Wise Engineering  
3915 Old Fairground Rd.  
Angier, NC 27501  
(919)894-2203

April 23, 2024

Subject: 910 NC-82, Dunn, NC 28334

A representative from Wise Engineering reviewed the home being constructed at the above address. Specifically, we reviewed the first-floor framing and wall framing damaged by plumbing lines.

FOUNDATION PLAN
 SCALE 1/4" = 1'-0"

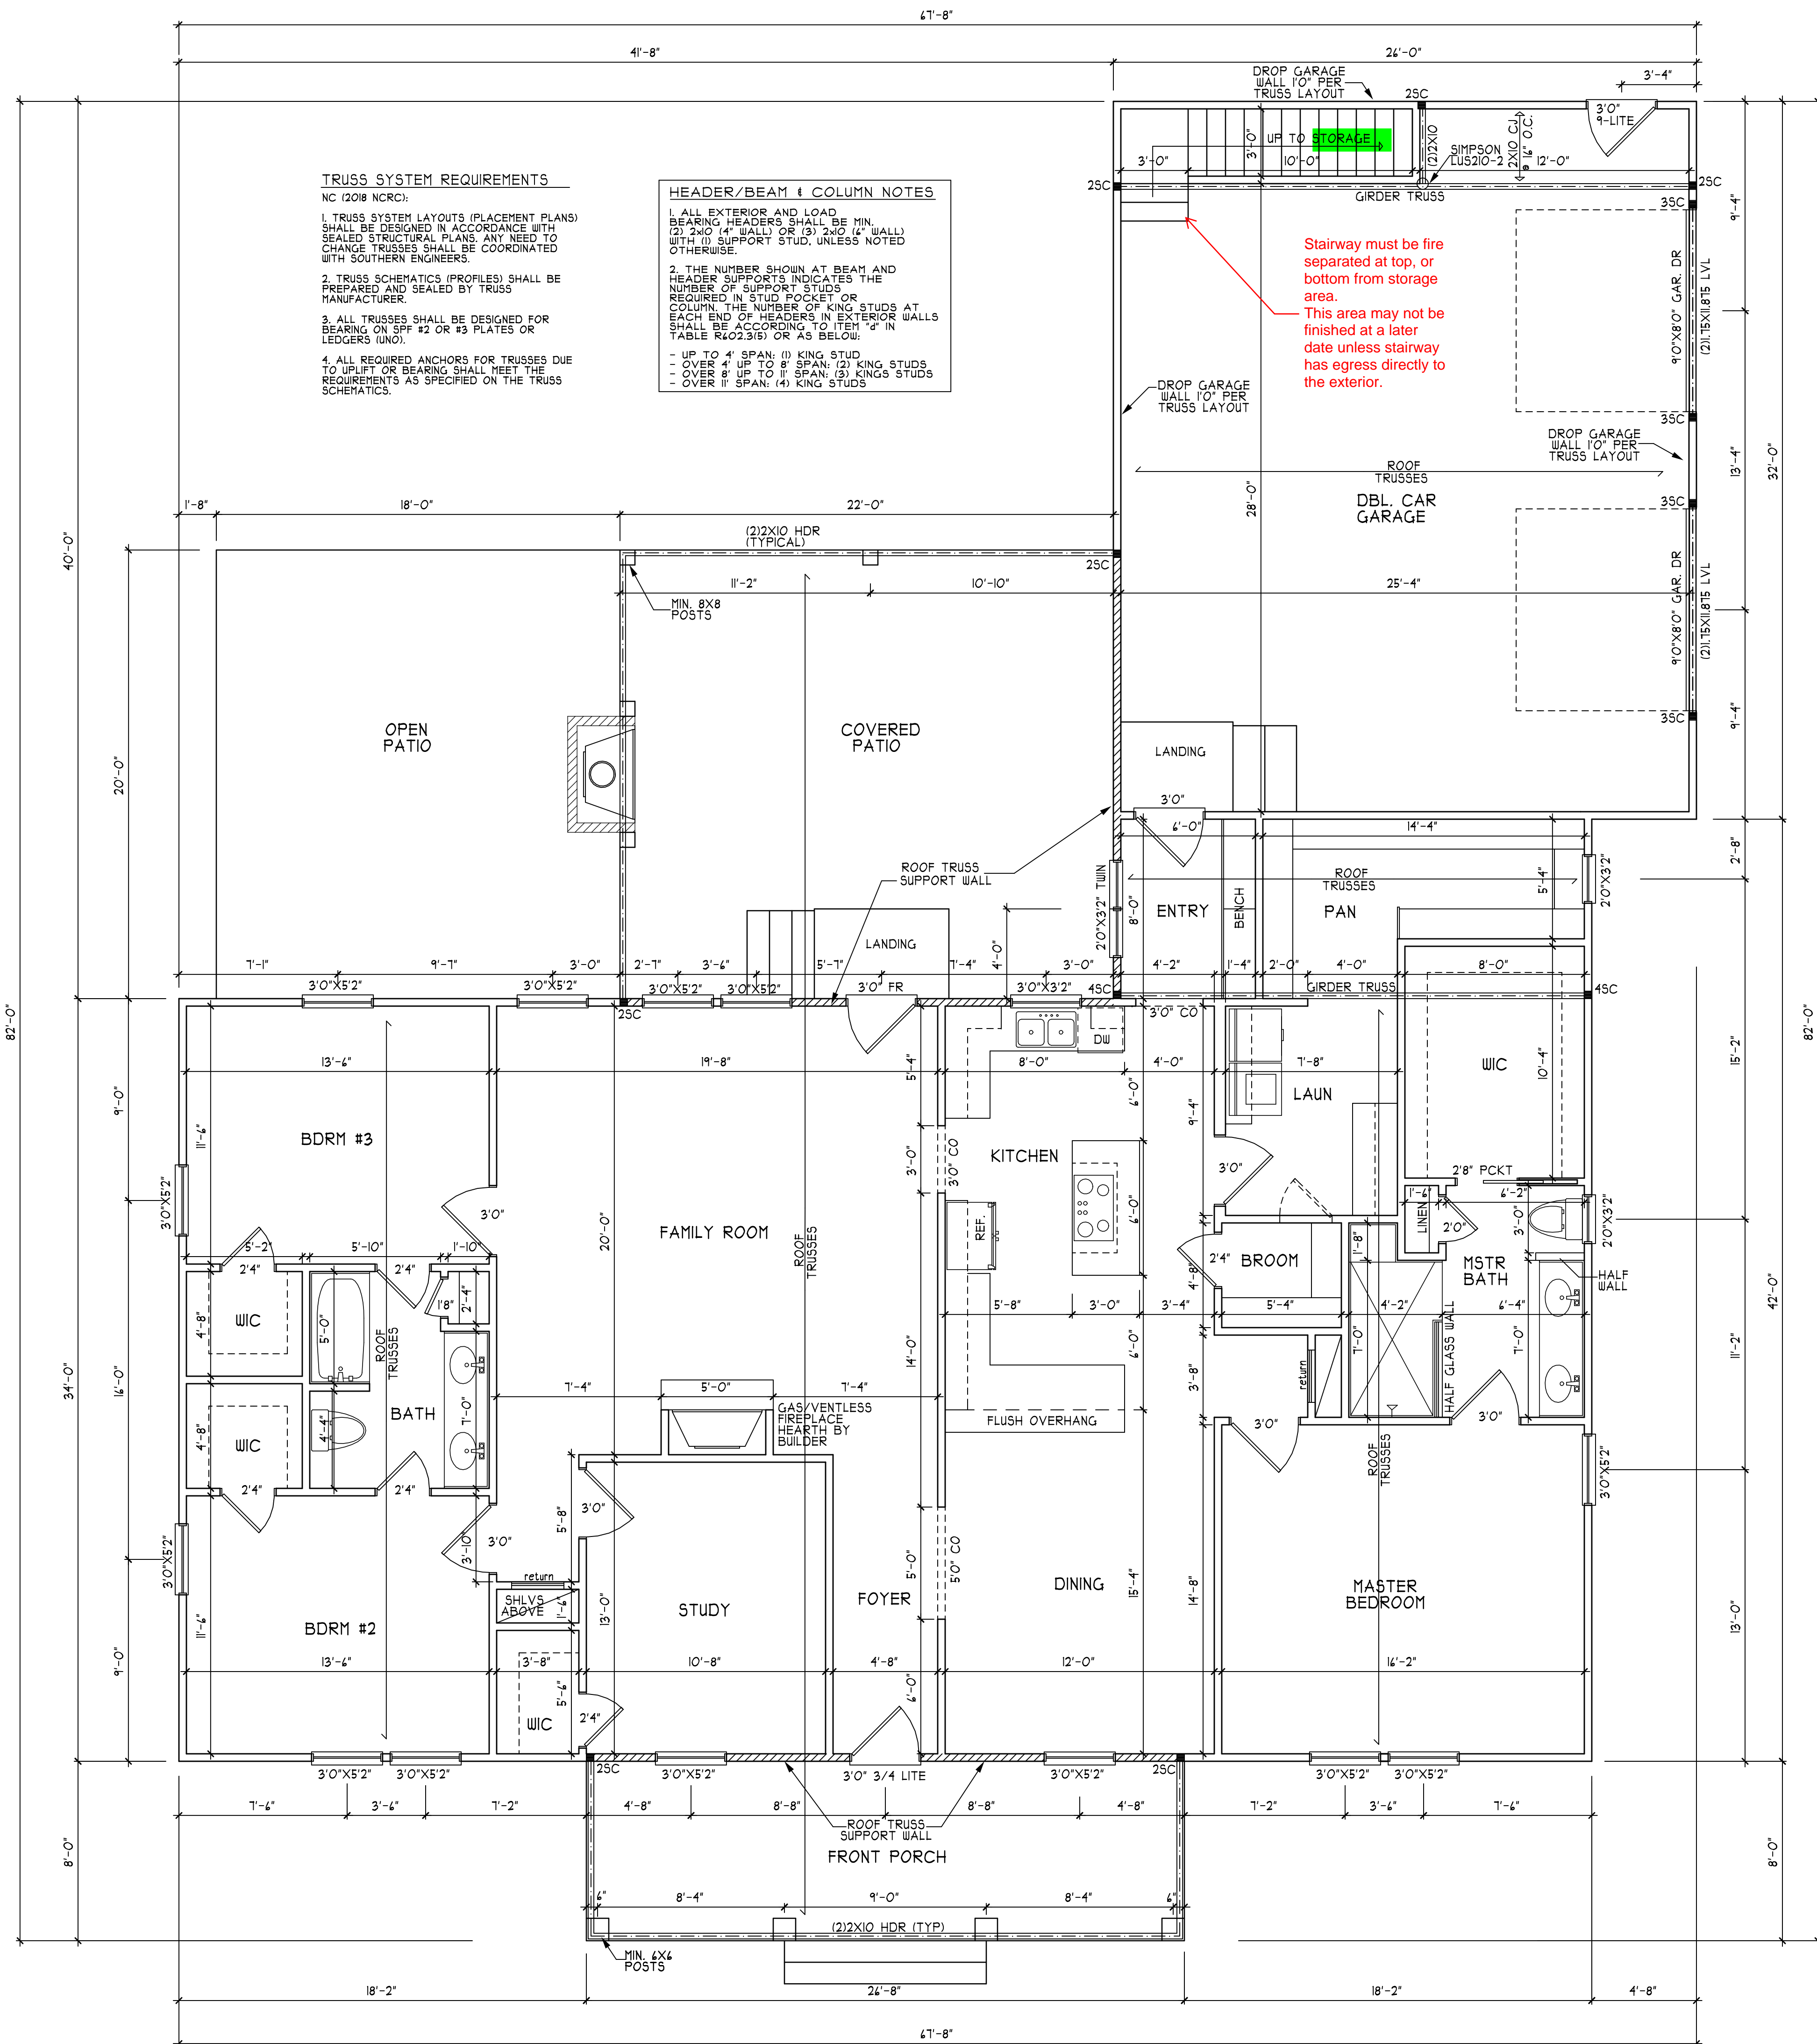
Based on my observations, it appears that holes for the plumbing were extended through 3 consecutive studs in the exterior wall at the right side of the home. This can be repaired by adding a stud shoe over the hole areas to provide additional strength to the stud. In addition, the plumbing for the toilet at the left side of the home, cut a floor joist from top to bottom approximately 2 foot from the main girder. I recommend installing a header to support the cut joist on the side of the cut away from the girder side and installing a "sistered" joist from the header adjacent to the cut joist back to the girder.

In summary, the stud shoes and the header installed to the cut joists are adequate to repair the plumbing holes and cuts and are structurally adequate in accordance with the 2018 NC Residential Building Code requirements.
